Springwell Solar Farm

Written Summary of Oral Submissions
at Issue Specific Hearings 2, 3 and 4

EN010149/APP/8.22
Revision 1
Deadline 3
August 2025
Springwell Energyfarm Ltd

**DOCUMENT:**  
ENVIRONMENTAL STATEMENT  
VOLUME 2: FIGURES  
REGULATION 5(2)(a) & 5(2)(l)(ii)

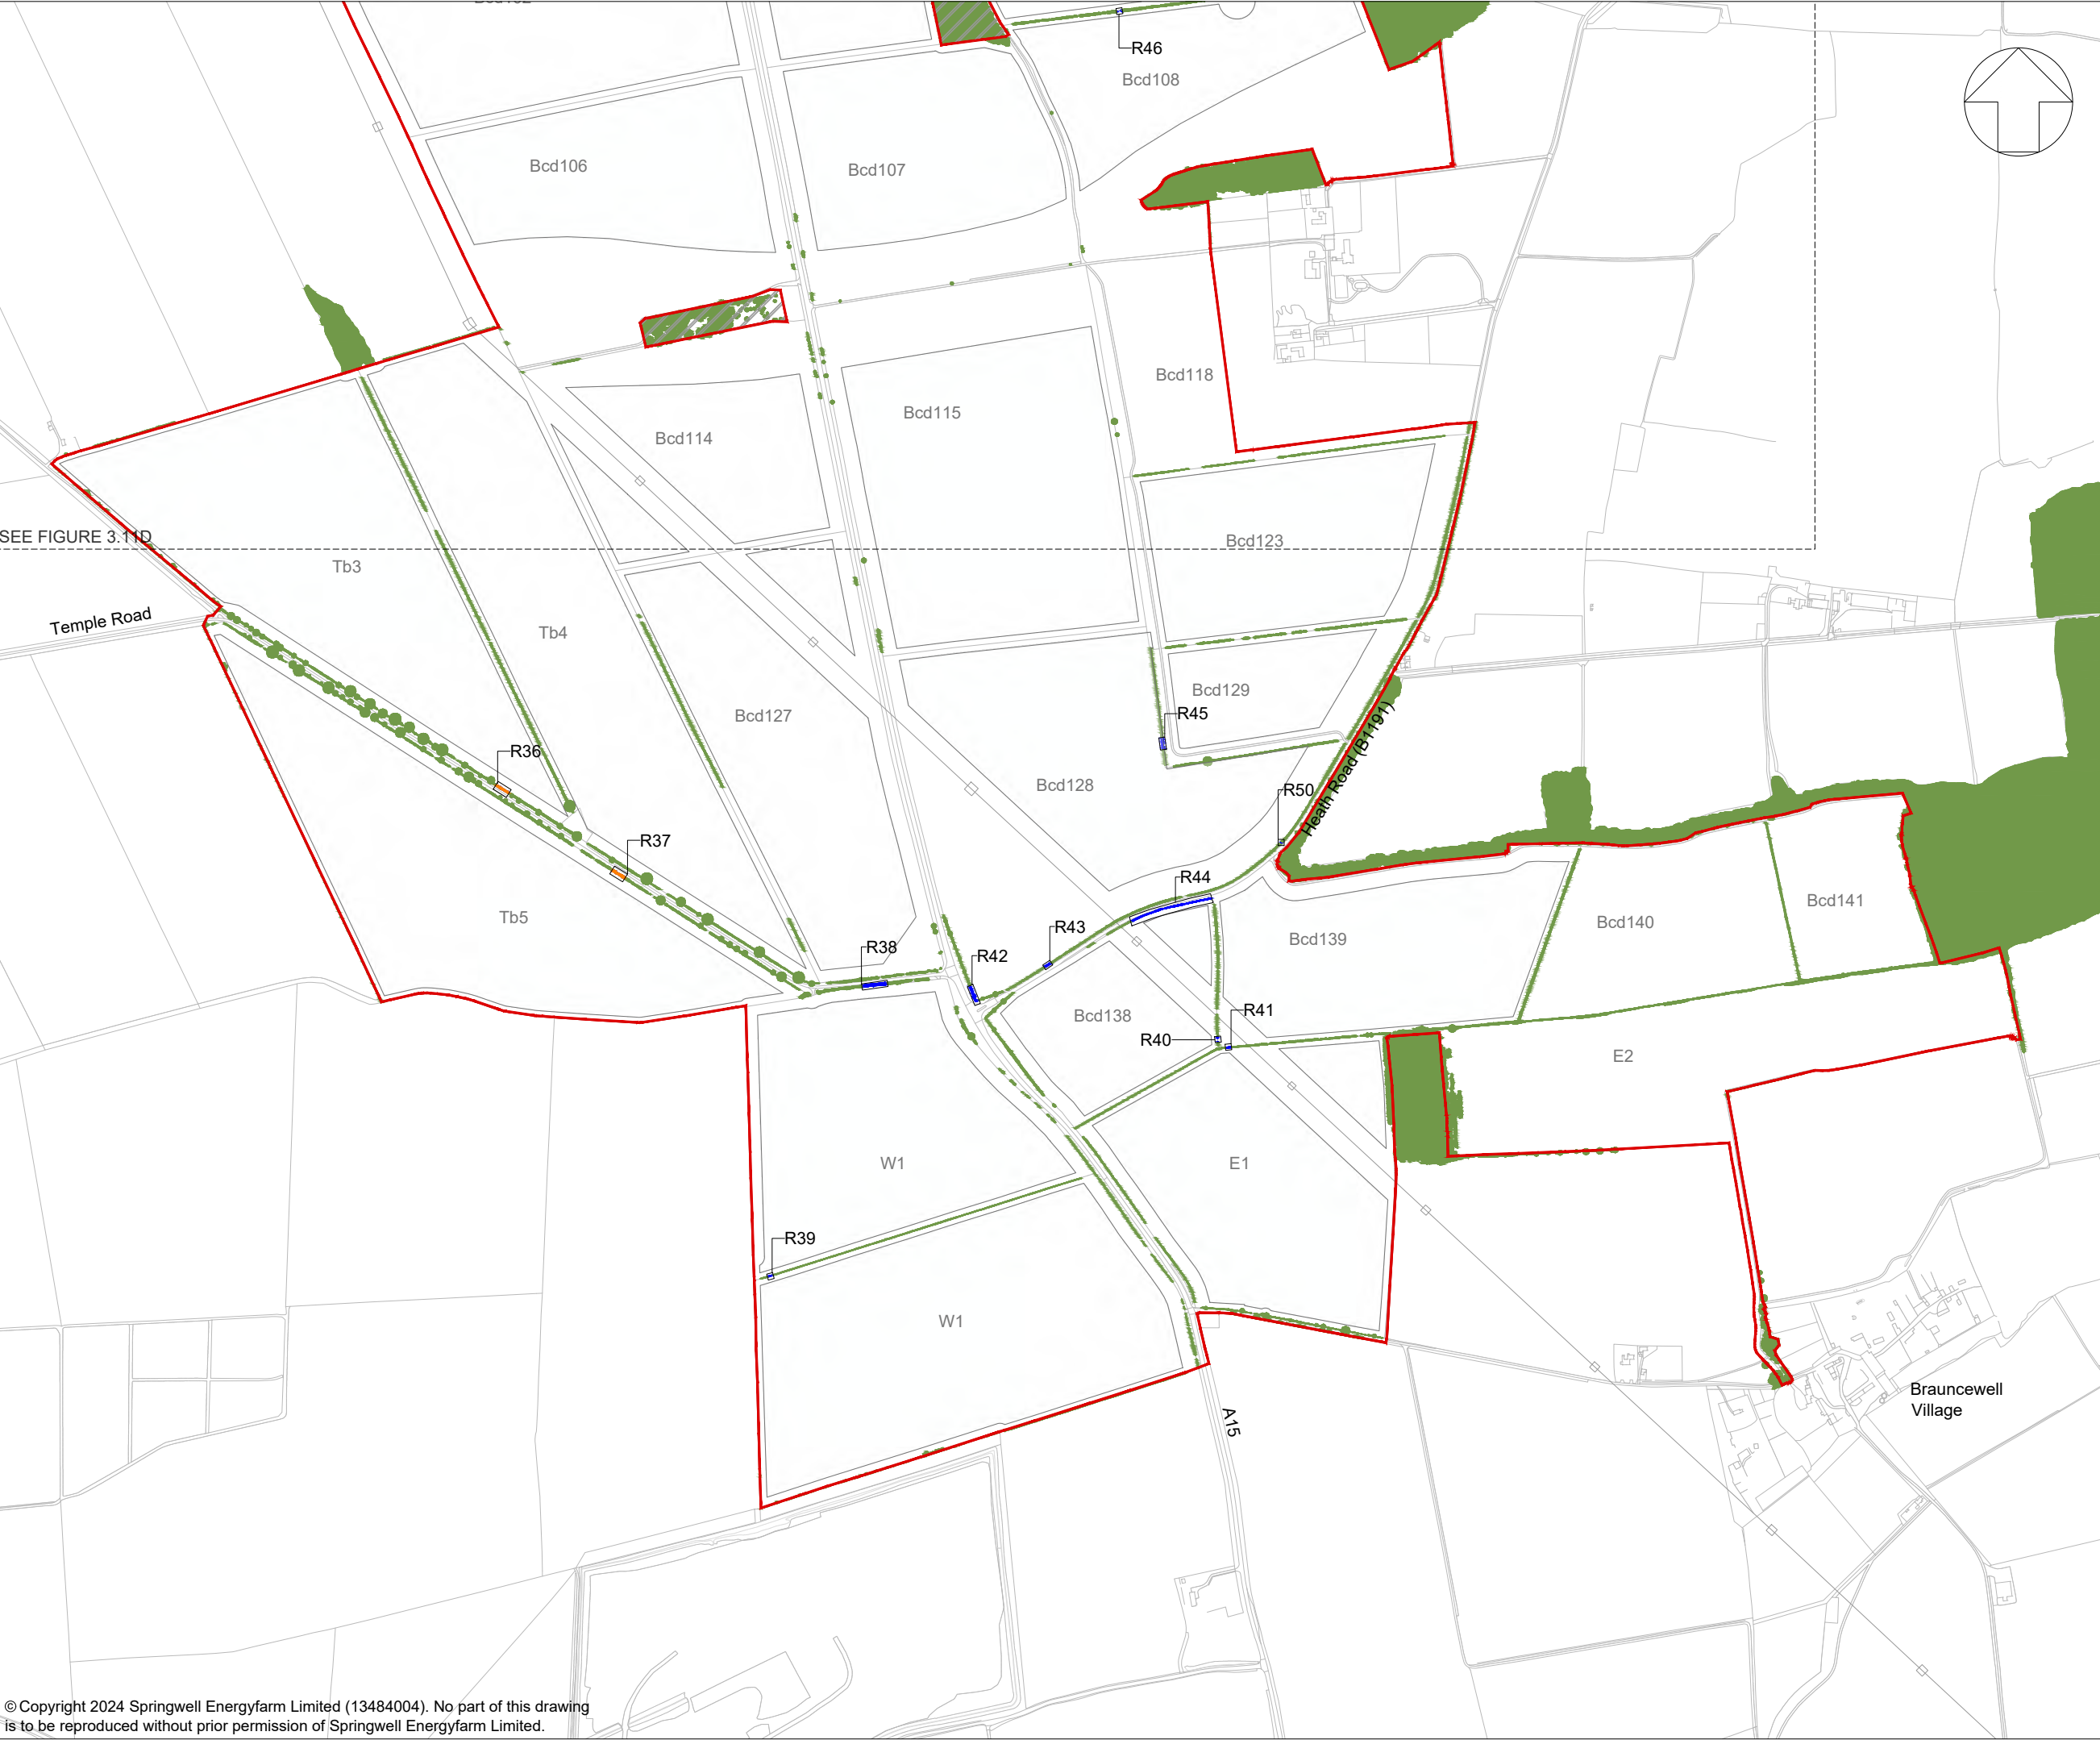
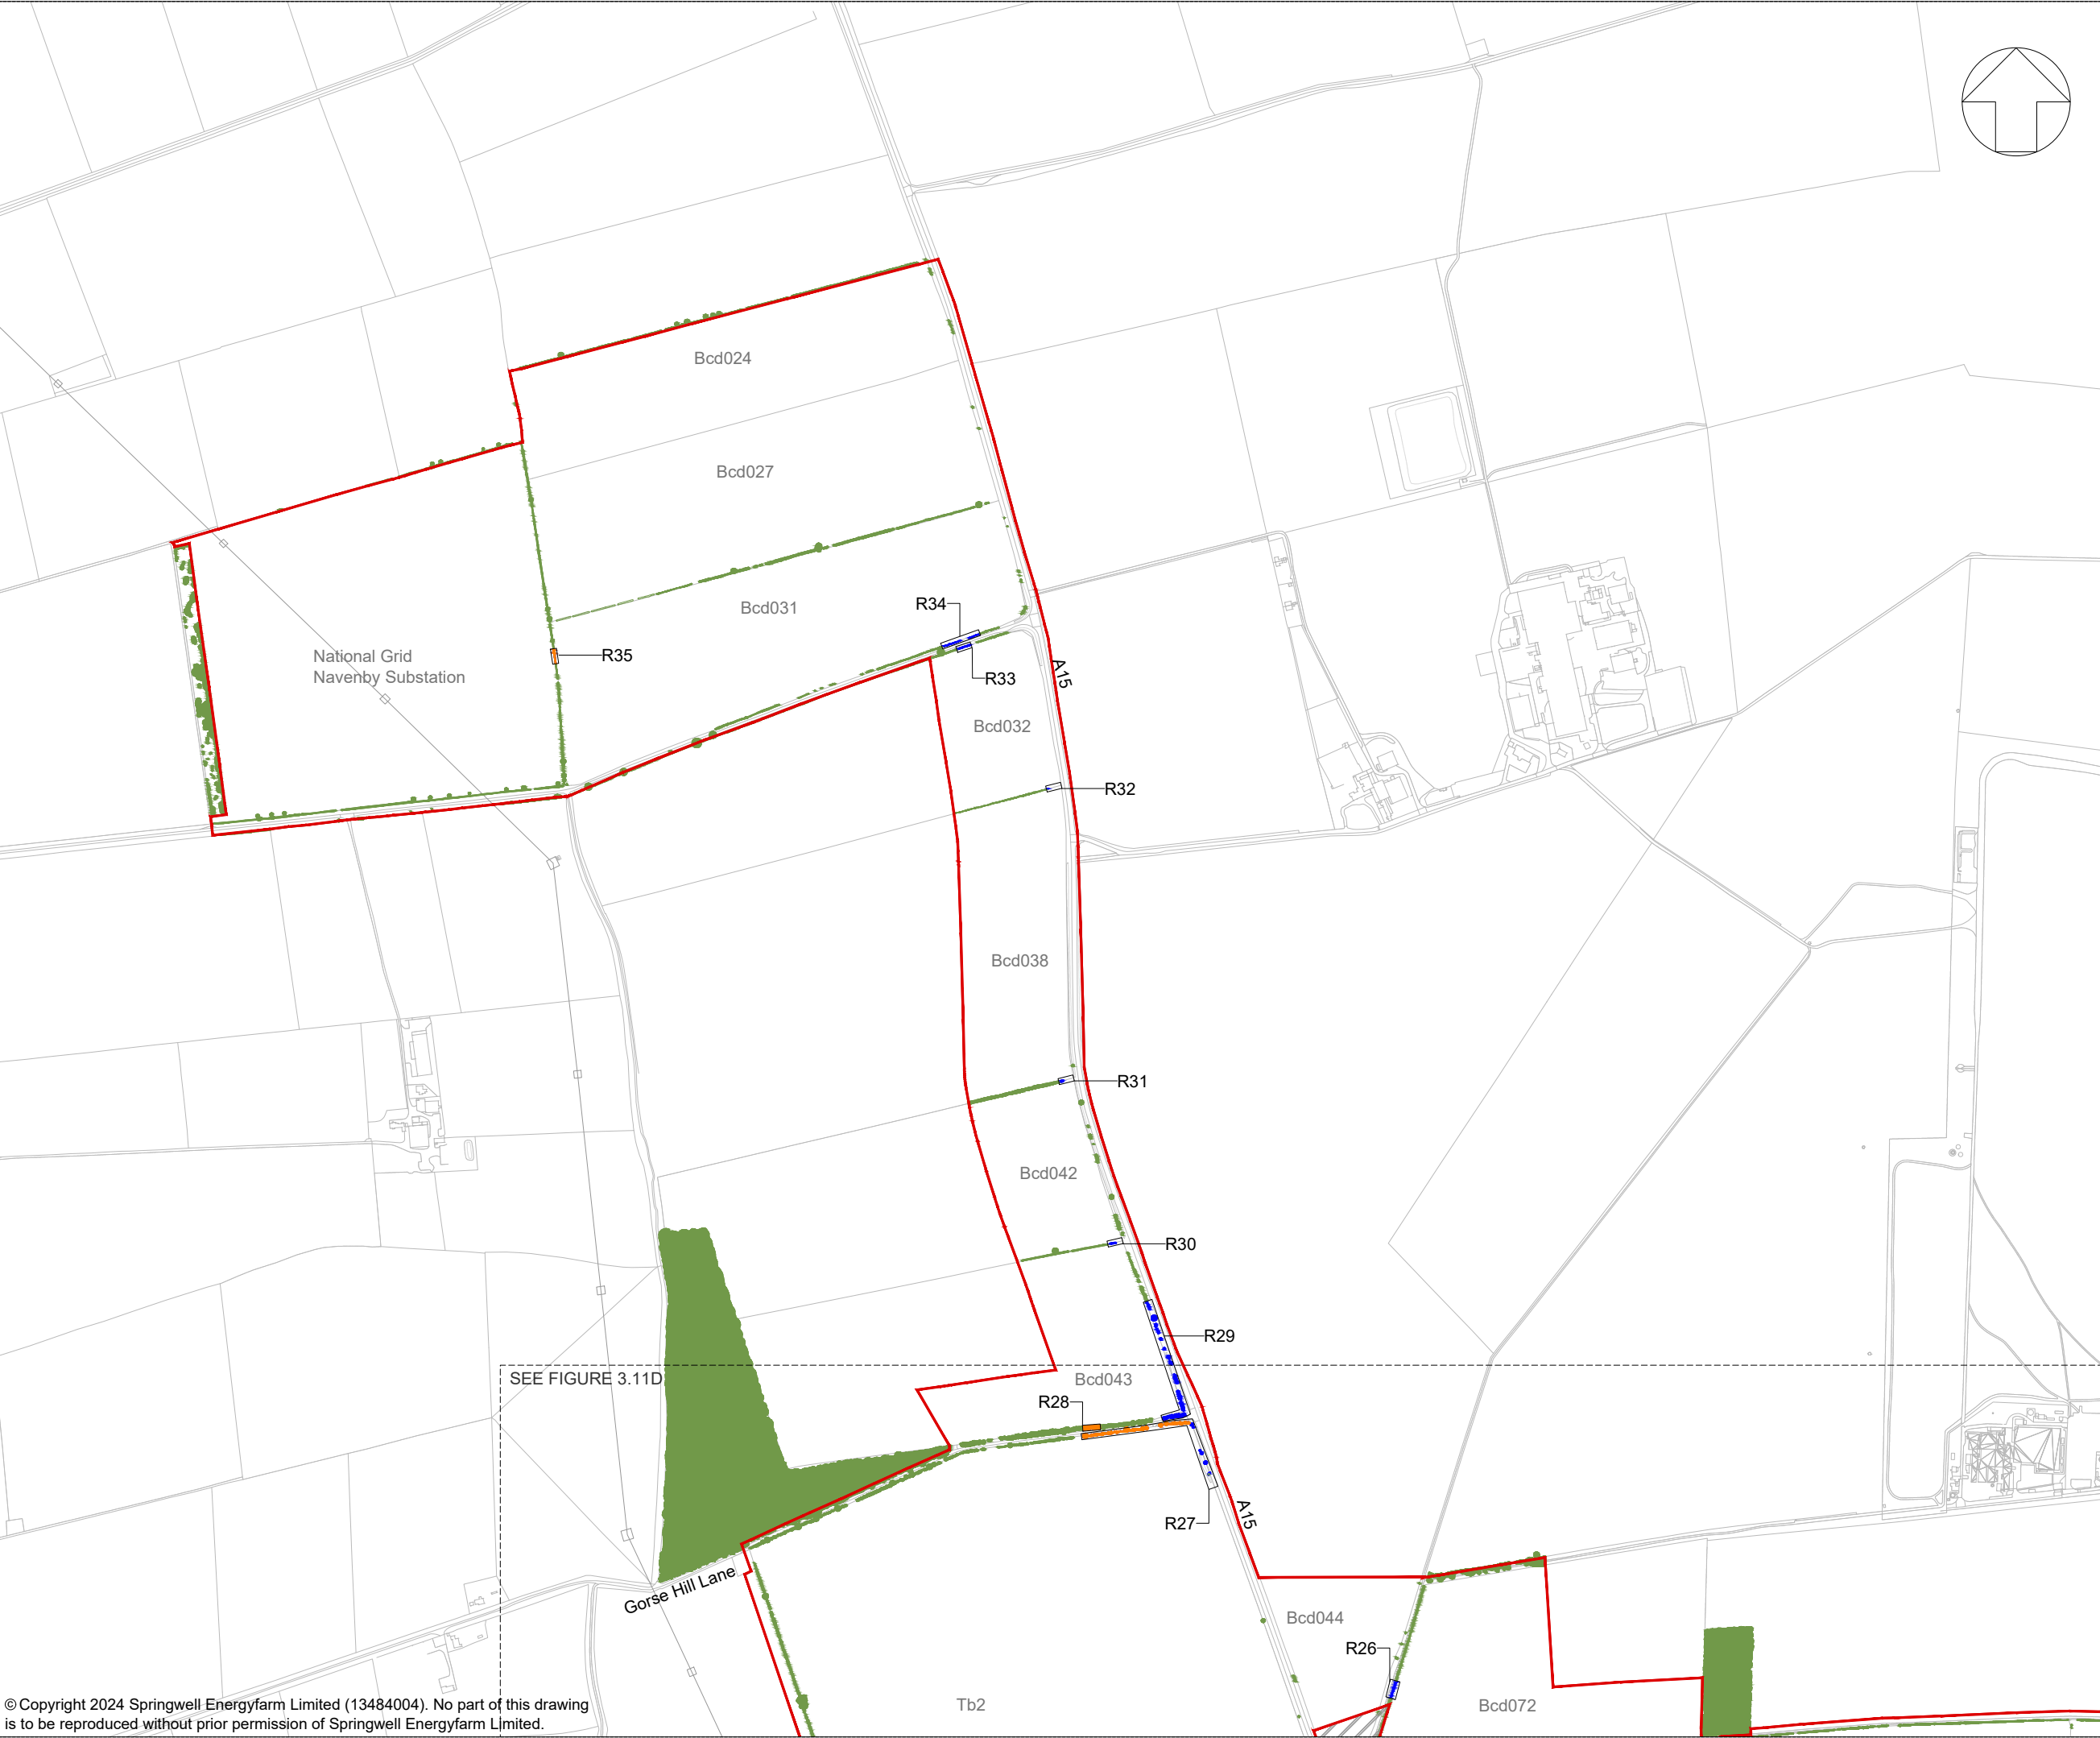
#	Agenda item	Written summary of Applicant's oral submissions at ISH 2
	3.3 The Applicant will be asked questions relating to the vegetation removal parameters (Figures 3.11A to 3.11F) [EN010149/APP/6.2.2] [REP1-027] and how landscape and visual impacts will be accounted for in finalising the location of vegetation removal.	<p>The ExA asked the Applicant if the vegetation removal parameters that are included in Schedule 13 of the Draft DCO [EN010149/APP/3.1.2] [REP1-006] are outline parameters that will inform detailed parameters. Mr Griffiths explained that the Applicant has applied a reasonable worst case approach in accordance with the Rochdale Envelope including the potential removal for these works.</p> <p>Mr Van der Nelson explained that the vegetation removal locations have been guided by the Project Principles and have included consideration of LVIA impacts as part of the pre-application design process. The vegetation removal parameters presented in the Outline Landscape and Ecological Management Plan (oLEMP) [EN10149/APP/7.9.2] [REP1-064] takes account of highways construction works, internal access tracks, cable routes and the grid connection corridor. He continued and explained that should the DCO be granted consent, detailed LEMP(s) will be produced for the Proposed Development in accordance with the DCO Requirement in Schedule 2 of the Draft DCO [EN010149/APP/3.1.2]. He added that the LEMP(s), as it could be one or more LEMPs, would require approval by the relevant planning authority prior to commencement of construction and would be required to be substantially in accordance with the framework set out in the oLEMP [EN10149/APP/7.9.2], including the Vegetation Removal Parameters presented in Appendix 2. Mr Van der Nelson explained that the Applicant has designed for a reasonable worst case and the design process means effects should get better. He continued that where future design choices need to be made, these will be guided by the oLEMP [EN10149/APP/7.9.2] [REP1-064], particularly the management objectives in section 4, such as the retention of existing vegetation wherever reasonably practicable (MO1), consideration of local landscape character (MO2) and protecting the amenity of PROW (MO9). The Design Commitments [EN010149/APP/7.4] [APP-0138] provide further controls regarding vegetation removal, for example, 'Internal access tracks and cable routes will use existing access tracks, crossings and/or gaps in the hedgerows where practicable' (D1) that the Applicant will need to demonstrate compliance with when the detailed design is submitted to the relevant planning authority under Requirement 5 of the Draft DCO [EN010149/APP/3.1.2] [REP1-006].</p>

#	Agenda item	Written summary of Applicant's oral submissions at ISH 2
		<p>The ExA asked the Applicant if the vegetation removal areas are to be in different areas to the vegetation removal plan or if will it be within refined areas of the parameter areas, and how will LVIA impacts be taken into account in finalising the vegetation removal. Mr Griffiths on behalf of the Applicant explained that there will be refinement in the vegetation removal plan as the Applicant has made a reasonable worst case assessment. As is established in case law, there is no obligation on a developer to assess every permutation that could arise on any scheme. In any event, Schedule 16 of the Draft DCO [EN010149/APP/3.1.2] [REP1-006] provides a safeguard because when approving the LEMP the Applicant will need to provide the relevant planning authority with a statement setting out if there are any new environmental effects, which the relevant planning authority will consider and confirm if they agree. If there is a difference that the Applicant could not predict e.g. because the baseline has changed, the Applicant would include that in its statement and the relevant planning authority can assess the difference through that mechanism and determine whether to approve the discharge of the requirement.</p> <p><i>Visual Impact and Design</i></p> <p>3.4 The Applicant will be asked about the design process that is secured in the draft Development Consent Order and control documents.</p> <p>The ExA asked the Applicant if there has been a design process to date that shows that the colour commitments in design commitment D17 are appropriate, such as a landscape colour study or a study of local buildings that have informed the issues. Mr Van der Nelson stated that the Applicant will come back in writing on this point, but in accordance with the requirement 5 in the Draft DCO [EN010149/APP/3.1.2] [REP1-006] the Applicant must have detailed design approved by the relevant planning authority.</p> <p>The ExA noted that Requirement 5 lists in accordance with the Design Commitments [EN010149/APP/7.4] [APP-0138], but wanted further information on how the colours in the Design Commitments [EN010149/APP/7.4] [APP-0138] had been identified. Mr Griffiths explained design commitment D17 states that the colours must be sensitive to the local environment, so when the Applicant submits the detailed design to the relevant planning authority that is the security mechanism. He also noted that the Applicant considers</p>

#	Agenda item	Written summary of Applicant's oral submissions at ISH 2
		<p>these colours appropriate and that consultation with the relevant planning authorities has been carried out, including on the project's design-led approach as set out in the oLEMP [EN010149/APP/7.3.2] [REP1-056]. He added that the colours are also not restricted to grey or dark green but could include other finishes to suit local building styles. Mr Van der Nelson explained the LVIA has fed into this design process too. The ExA clarified that the principle of the query about colour choice in the Design Commitments [EN010149/APP/7.4] [APP-0138] applies to all of the larger components of the Proposed Development, including Work Numbers 2, 3 and 4.</p> <p>Mr Samuel Sheikh, Counsel for North Kesteven District Council (NKDC) raised a concern about the flexibility at the discharge of requirements stage, as the Design Commitments [EN010149/APP/7.4] [APP-0138] specifies specific colours. NKDC will put their views in writing. The ExA asked the Applicant if any consultation had been held on these colours. Mr Griffiths confirmed there had been consultation on the Project Principles (which are the design principles considered as part of the DAD). The Applicant will respond in writing if it considers it appropriate to provide any more flexibility to amend the design principles.</p> <p>Post hearing note: The Applicant has provided a written response to address the points raised in this section in Action Point 2 and Action Point 3 of the Response to Action Points, which is appended to this document.</p> <p>3.5 North Kesteven District Council will be asked to expand on its concerns relating to the visual impact of highways components.</p> <p>Mr Oliver Brown for NKDC confirmed that the Applicant has clarified what was included in the vegetation works. There has been a meeting with the Applicant and they have clarified how the process will work – including the vegetation removal plans within the oLEMP [EN010149/APP/7.9.2] [REP1-064] and how it is secured within the Draft DCO [EN010149/APP/3.1.2] [REP1-006]. He added that NKDC is happy in terms of the information that has been presented in the vegetation removal plans and the information presented in the LVIA.</p>
